DSU - DEVELOPMENT ADVISORY PANEL RECORD OF MINUTES

1. Date and time of Meeting 10 April 2014

4. Development proposal Proposed Cold Storage warehouse & distribution facility.

Title: SITE PLAN SHOWING TRANSGRID CABLES

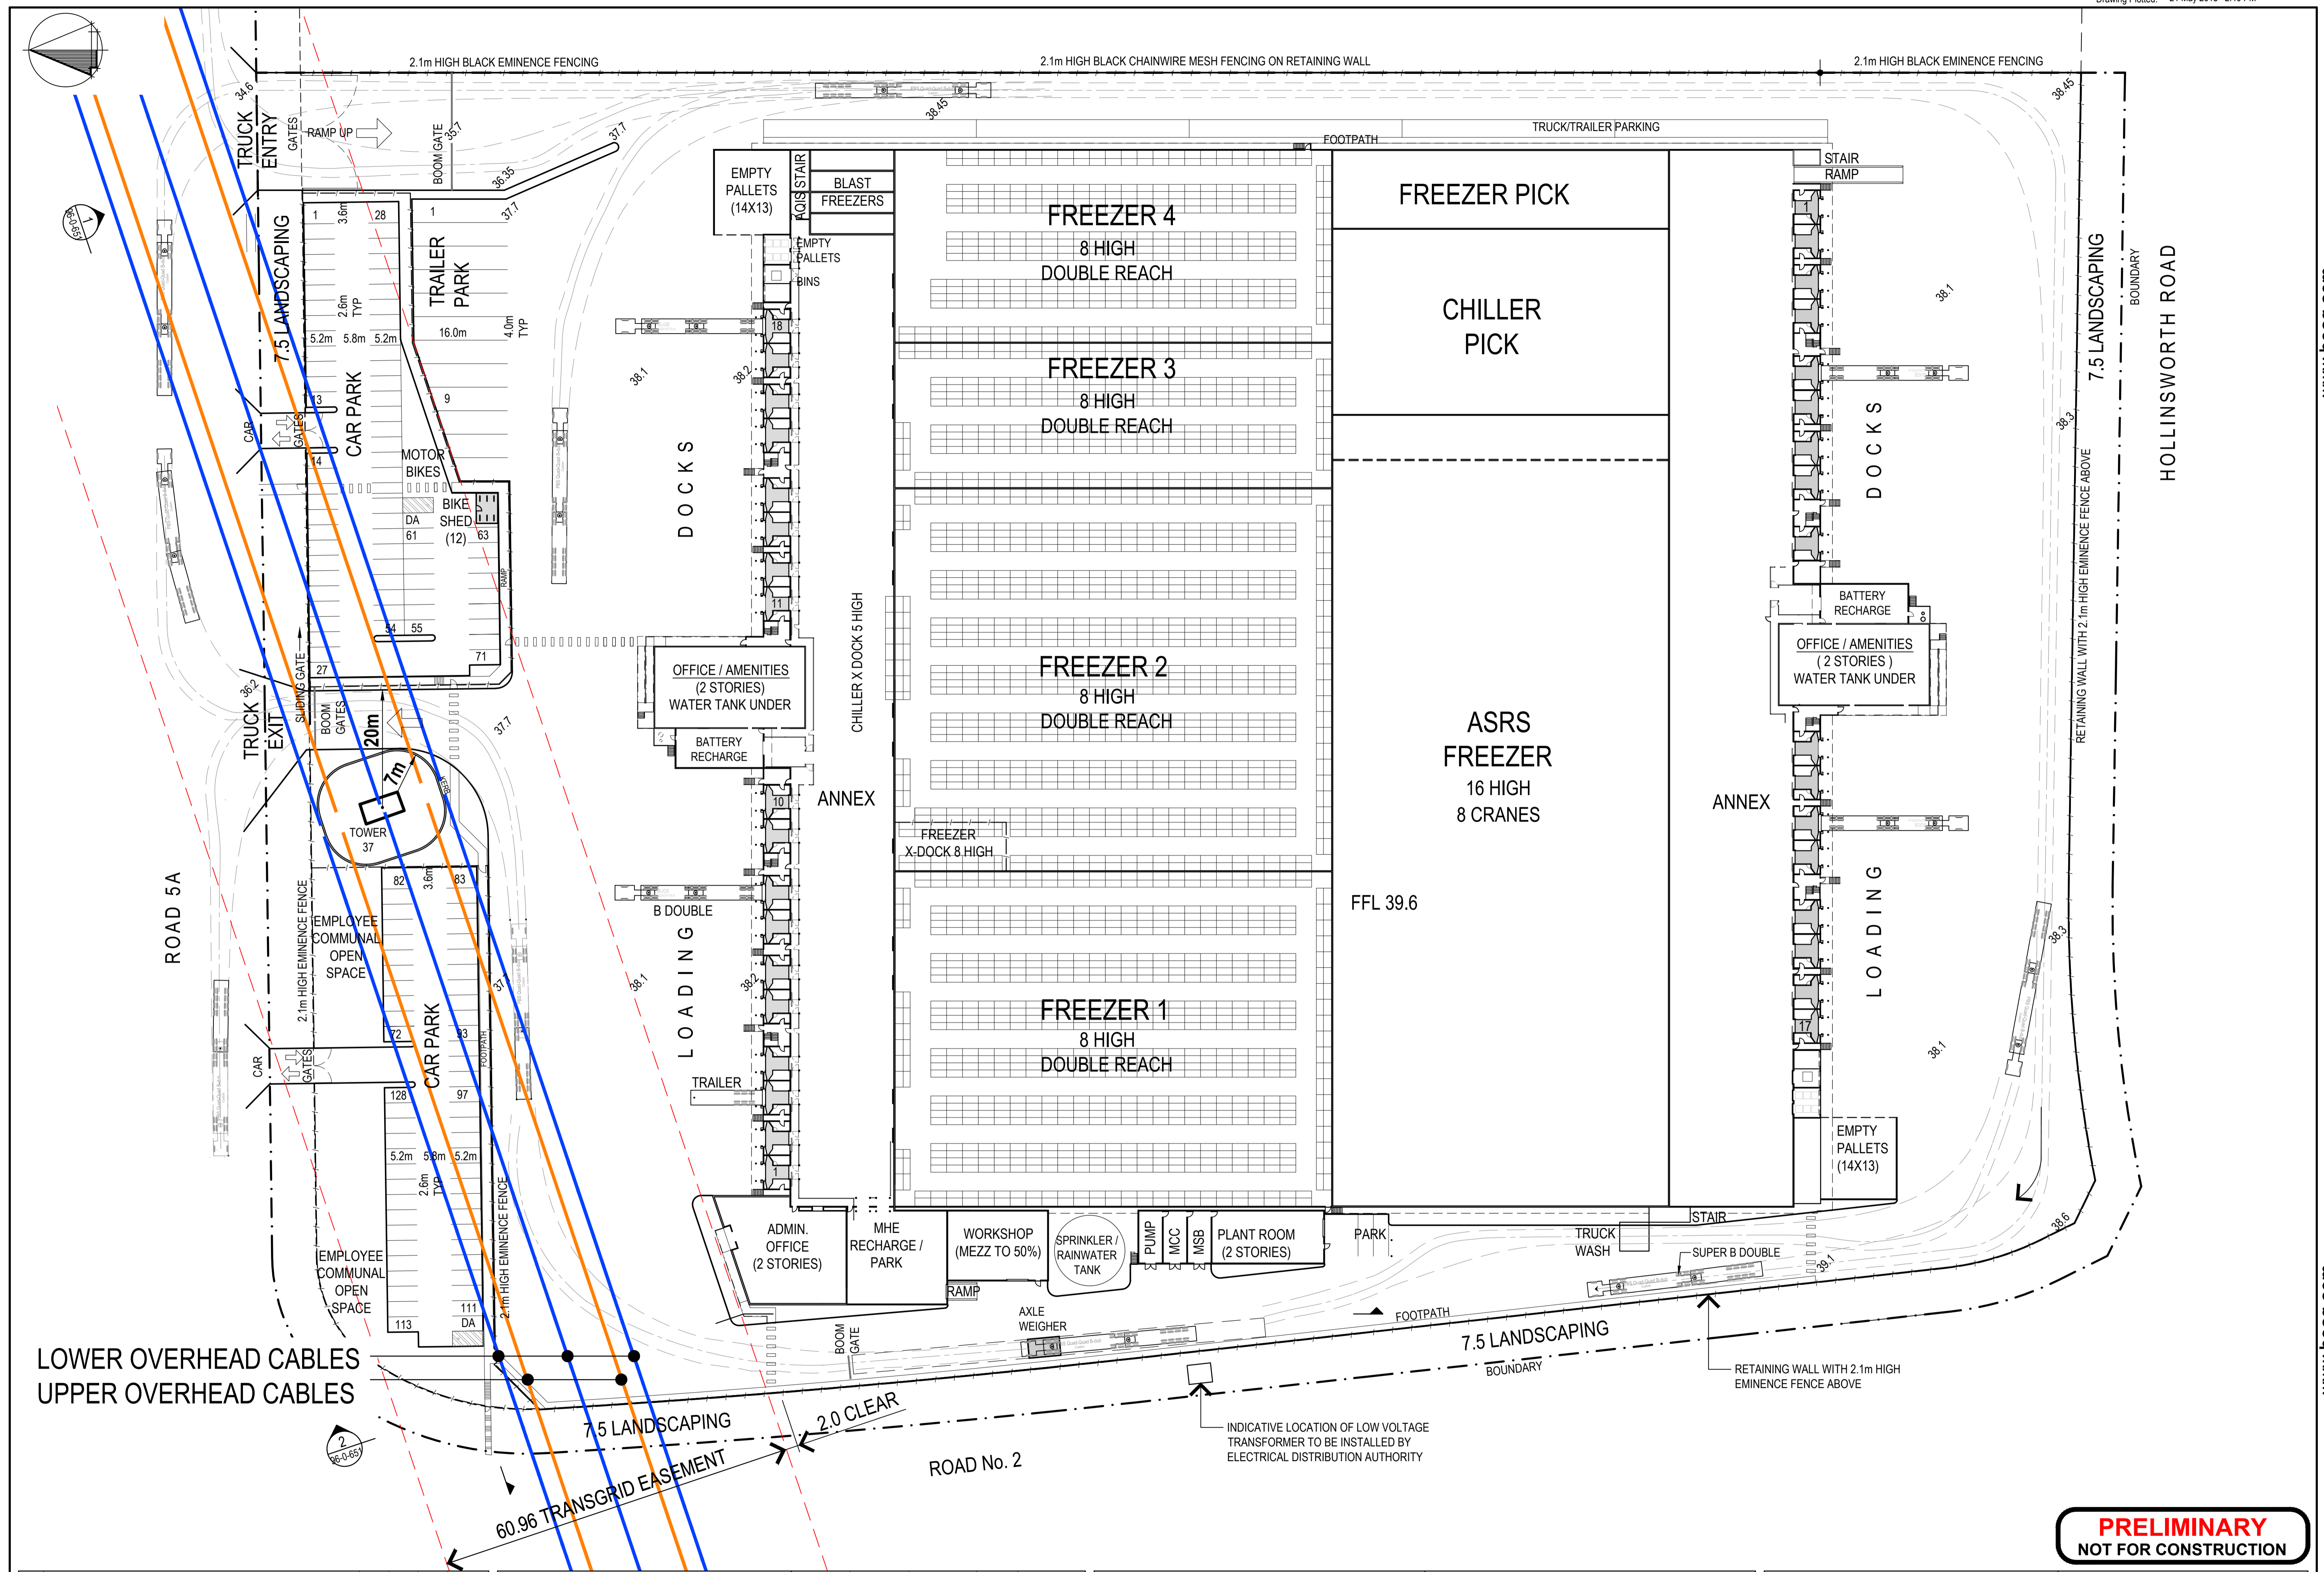
- Check with Transgrid distance to the driveways that they require. Also check what restrictions Transgrid impose under the transmission line in terms of height, landscaping etc.
- The driveway entry/exit points cannot be located where currently shown (not opposite an intersection) - need to shift it more midway - at least 30 to 35m
- Noise report - applicant should consider the nearby caravan park - for sleep disturbance criteria & impacts on it as the caravan park is going to be staying.
